Subject: RE: Y/9818/RES and Y/97/18/DOC

Laura Gibbons, MEng, GMICE
Engineer (Drainage & Coastal)

Scale NTS @ A1	Date JAN 19	Designed SG
Drawn TSB	Checked SG	Approved LH
Job No 18-070	Drawing No 18-070/112	Rev C

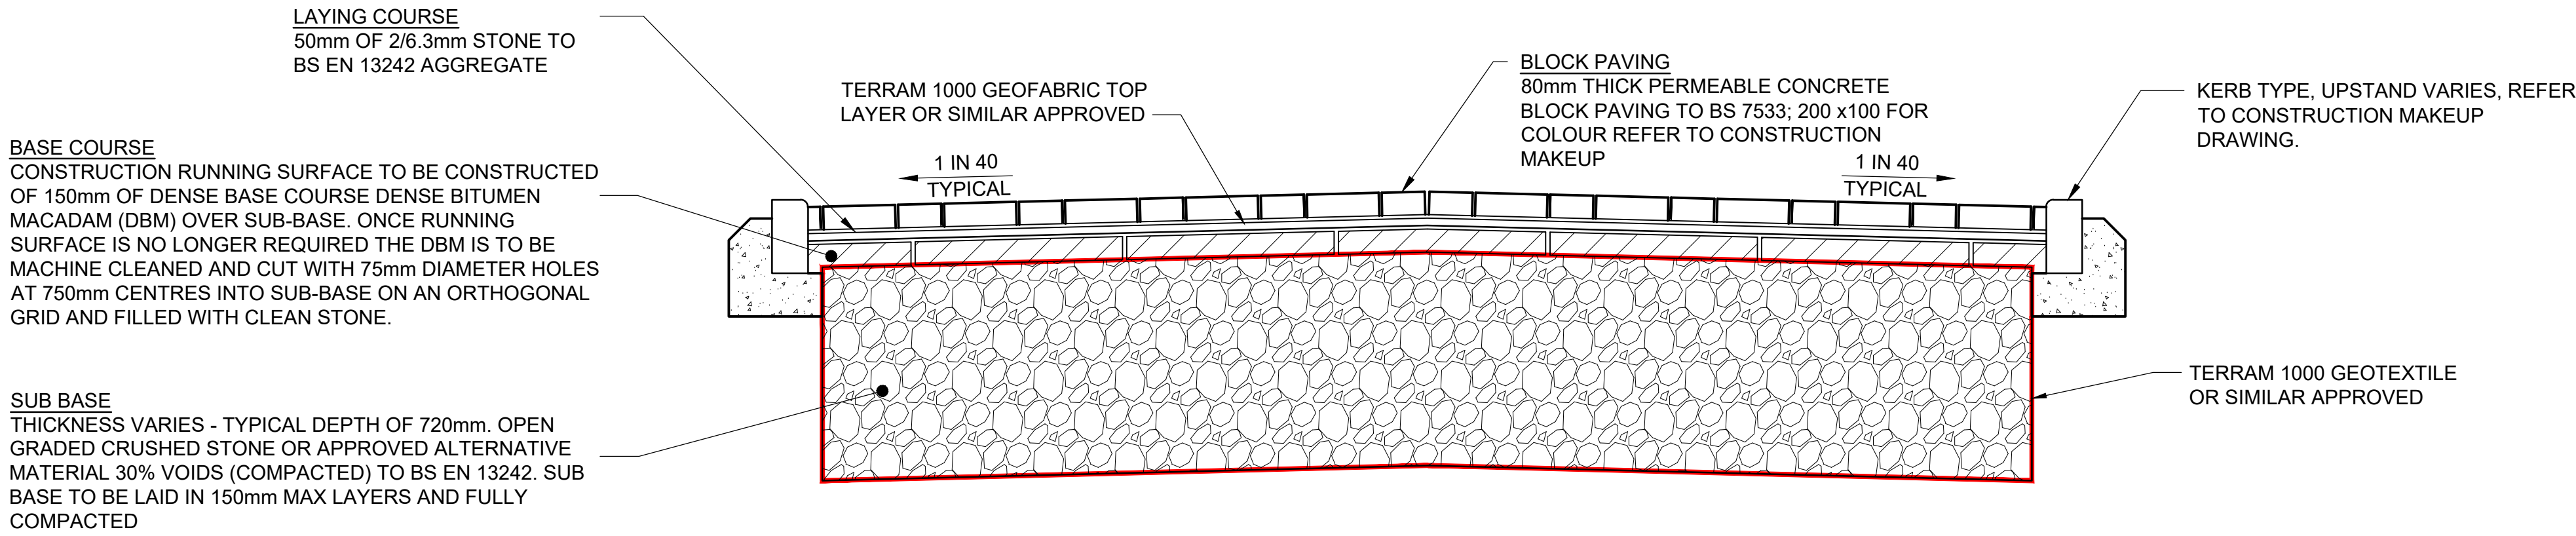
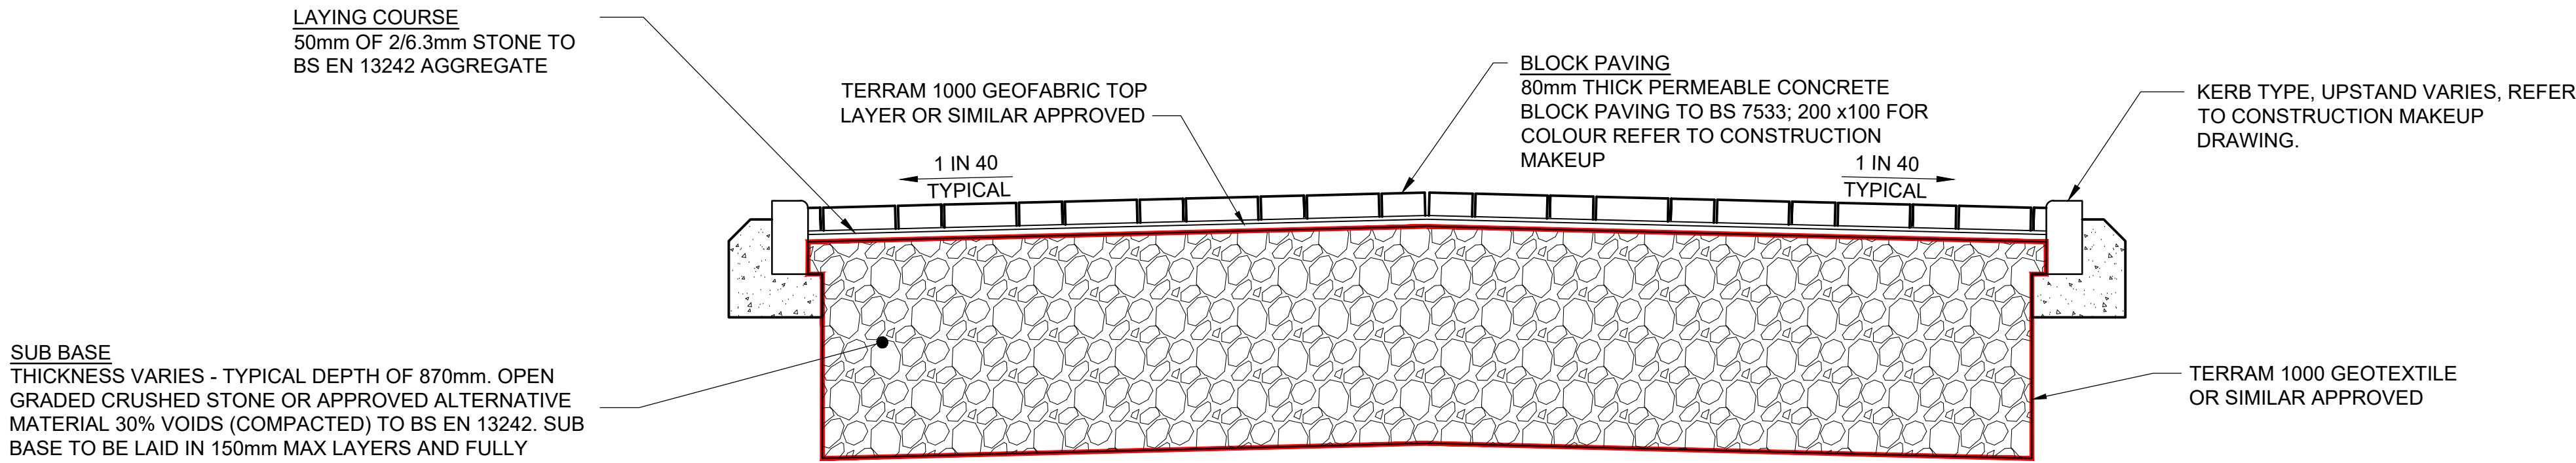
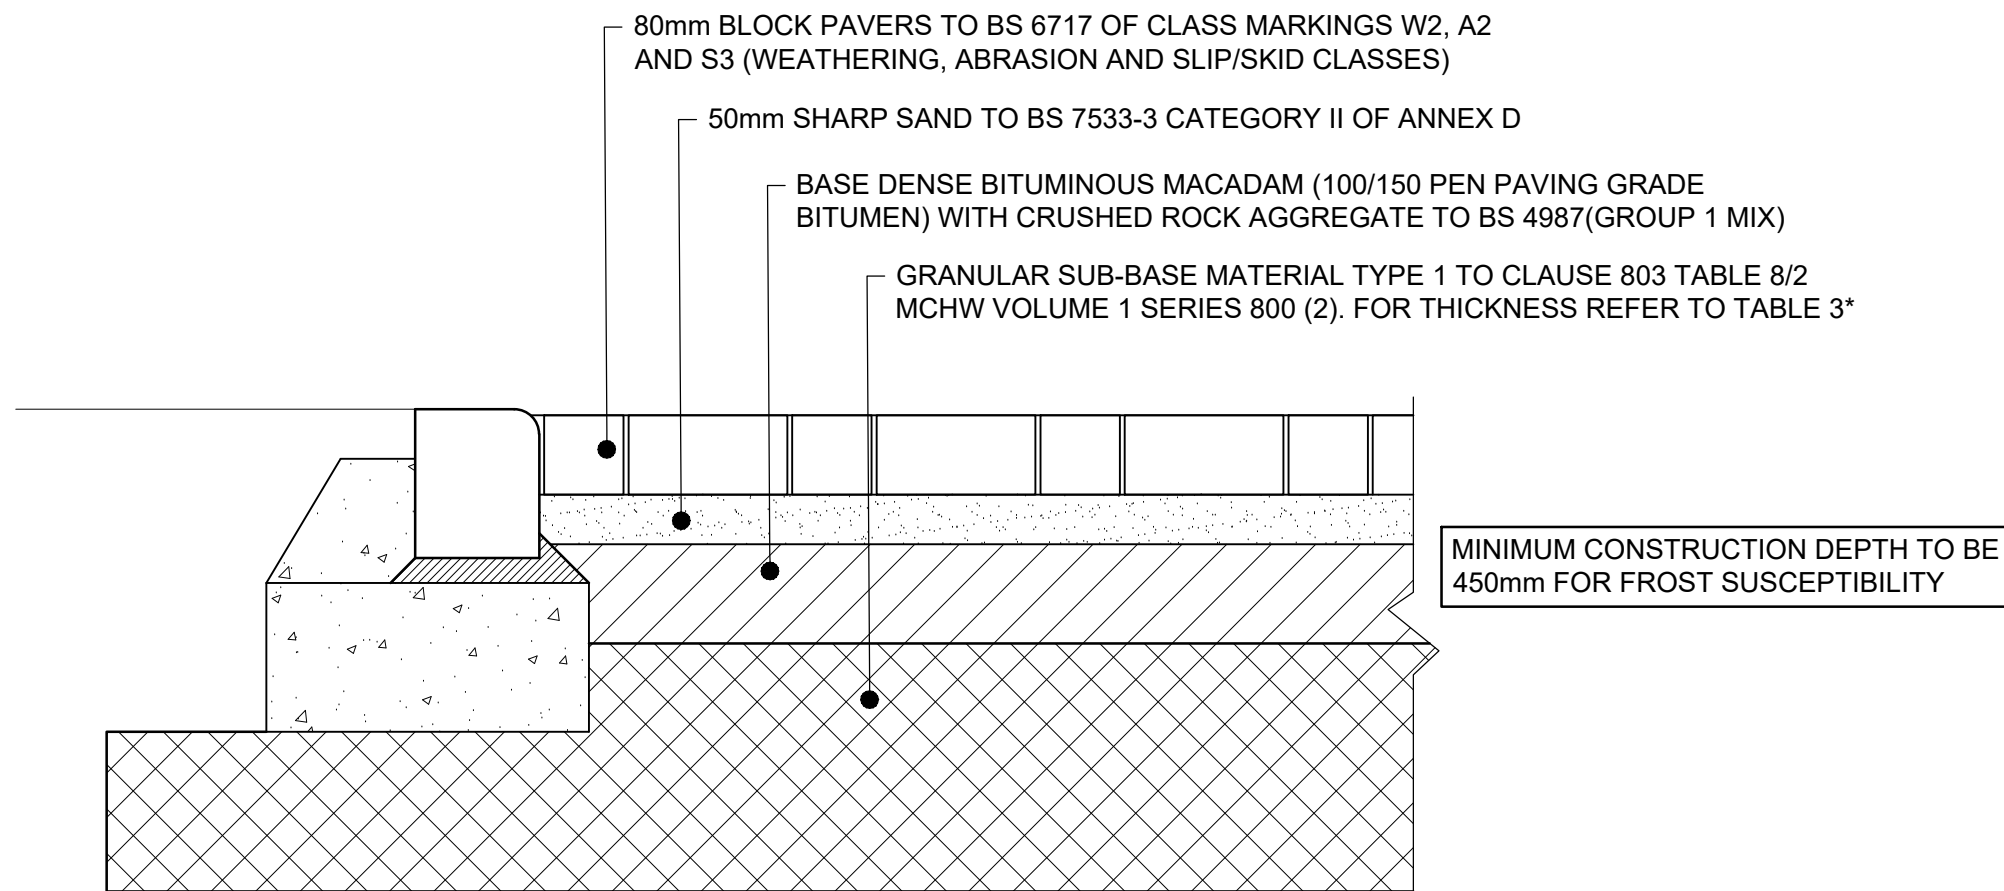
5. Please update the construction detail drawings to show permeable geotextile wrap fully around the sub-base. Detail has been updated. *Please update so geotextile is under tarmac, not over it.*
